From: Maria Tomalova <Maria.Tomalova@arun.gov.uk>
Sent: 15 January 2021 14:30
To: Planning.Responses <Planning.Responses@arun.gov.uk>
Subject: FW: AL/89/20/PL - Fmr Aldingbourne Post Office, Woodgate

Subject: AL/89/20/PL - Fmr Aldingbourne Post Office, Woodgate

PROPOSED GROUND FLOOR PLAN 1:100 @A3

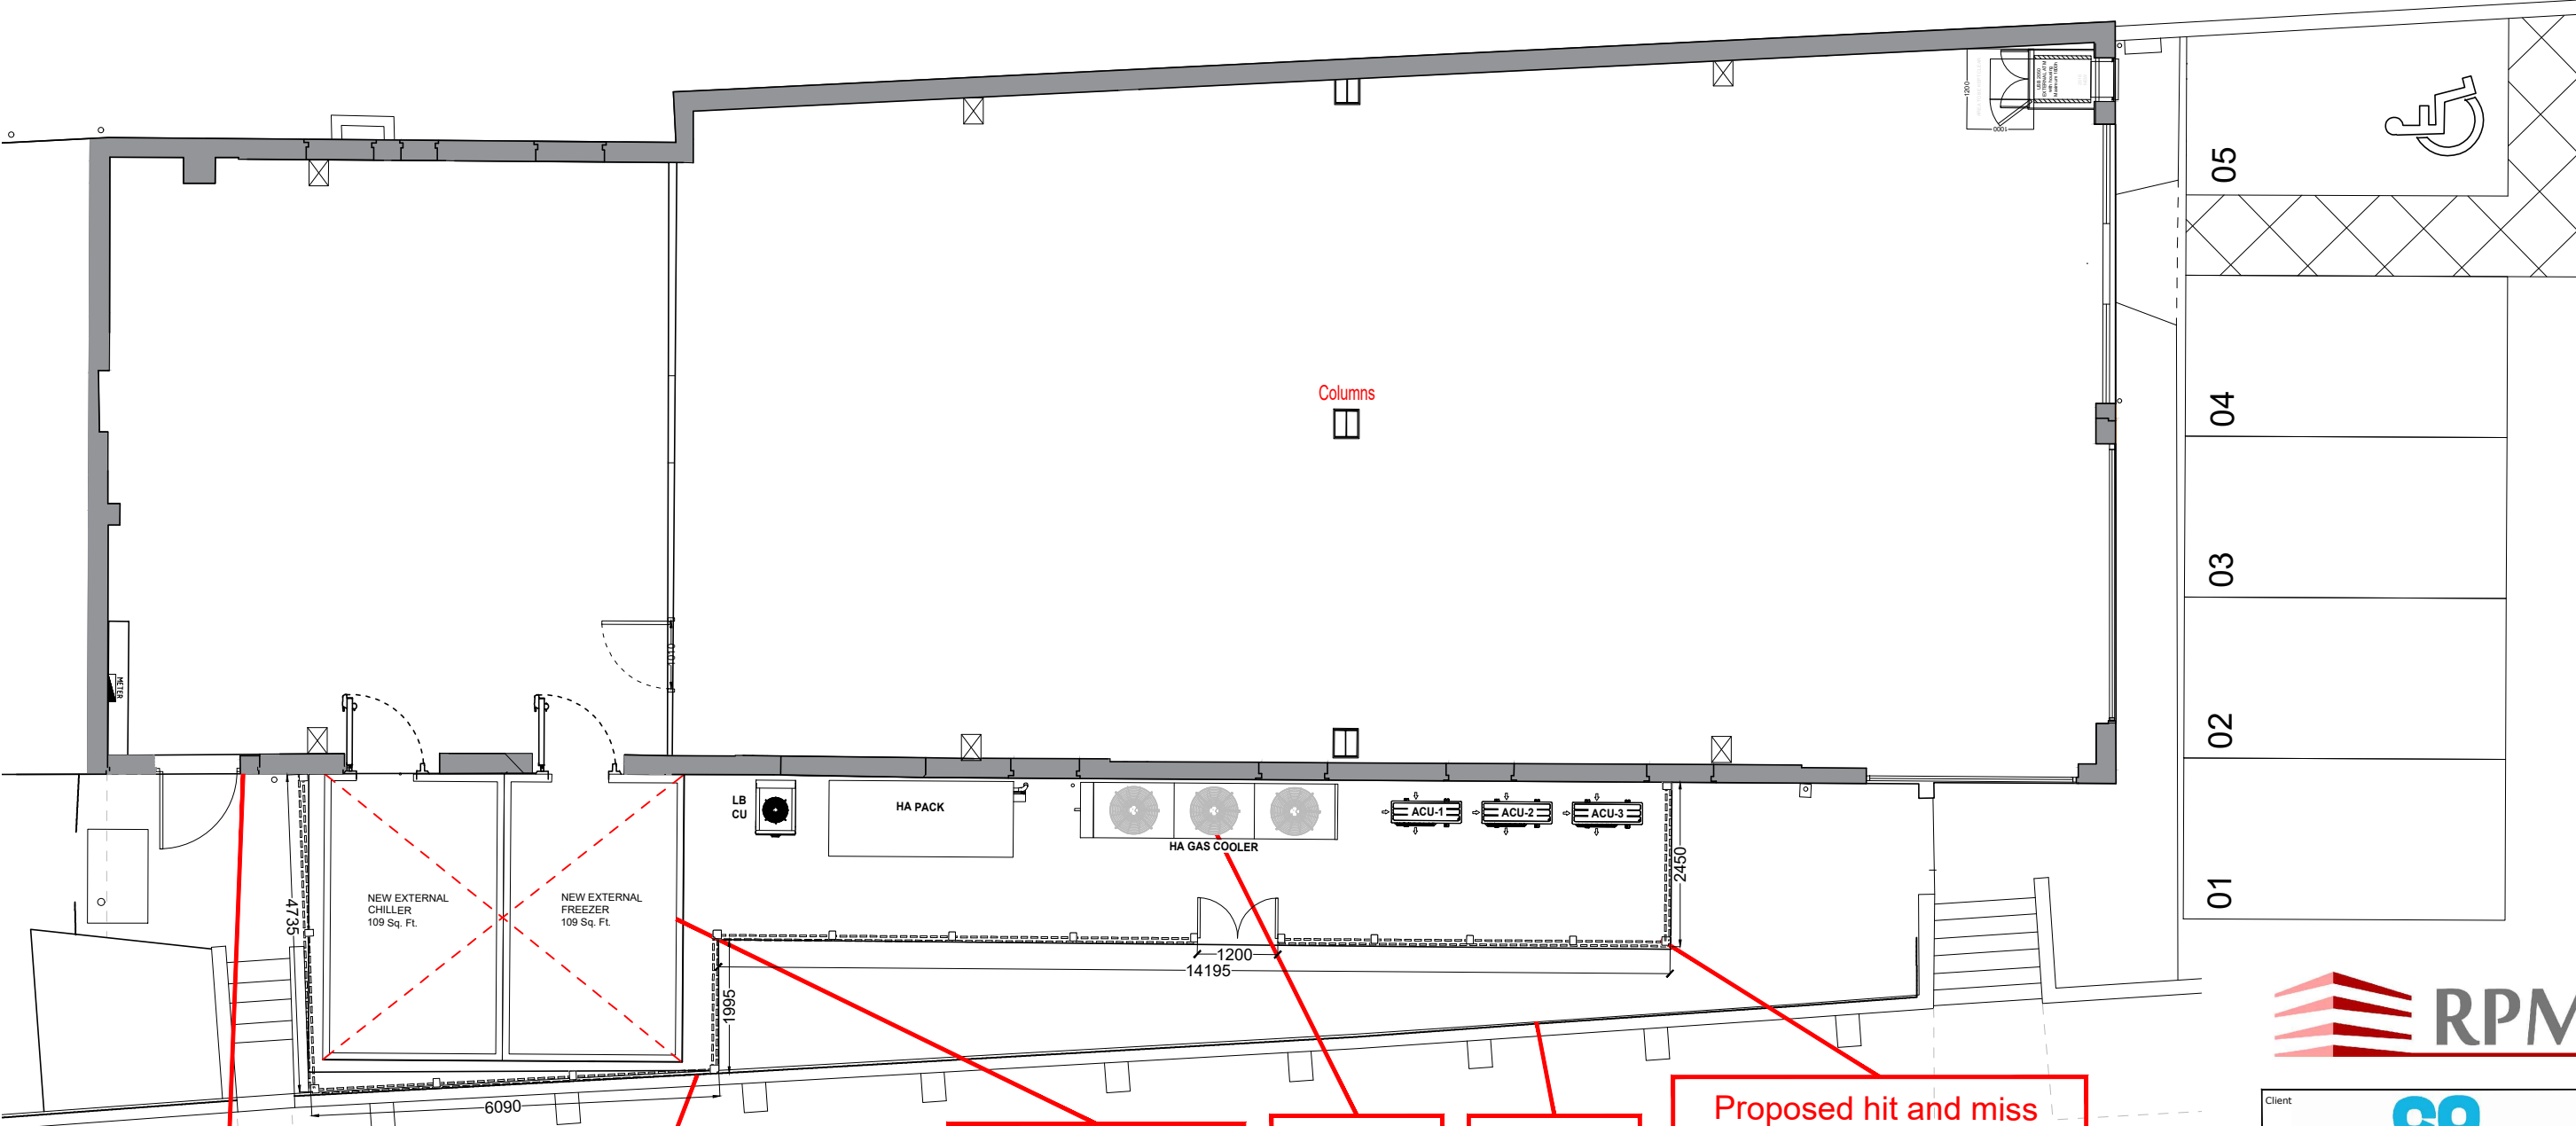
Even though the EH Officer did not object it subject to condition, I am concious of impact of proposed On residential immediately on the opposite site and to the left of the proposal.

This is very unpleasant monotone noise (irritable) and if it is even during night it is even worse since there is almost no bacground noise it could be unbearable.

What is more, the sound is spreading in the sphere as such hit and miss timber fence would not work.

For the reason above, the condition will be imposed to the decision:

'Before the proposed refrigeration and air conditioning plant is used on the premises, it shall be enclosed with sound insulating material and mounted in a way which will minimise transmission of structure-borne sound in accordance with a scheme to be agreed with the Local Planning Authority. The noise mitigation scheme should be maintained and shall not be altered without the prior written approval of the Local Planning Authority.'

I have discussed this in detail with my client and, given that it will take them some time to source the enclosures they are willing to agree the condition as suggested. If there are any other issues that arise, please do let me know.

The tonality of the plant has been addressed in the calculations within the Statement and is taken into account in the assessment of the impact on the nearest residents. The noise Impact Assessment also uses measured background noise levels throughout the day **and night** to compare with the predicted plant noise and therefore the assessment we have provided takes into account all the impacts that you have raised in your email. Page 17 of the report sets out the levels in full. The assessment concludes that with the enclosure and mountings proposed, there will be no adverse impact on amenity. Whilst I appreciate that decibels do not necessarily give the whole story, noise limits are set in terms of decibels and this is the measure against which impacts are assessed, in accordance with the relevant British Standards and the requirements of the Local Plan.

Given that this has been agreed by the Environmental Health Officer, and without any evidence that their response, and the assessment we have provided is incorrect, I do not see that it should be necessary to install additional mitigation here.
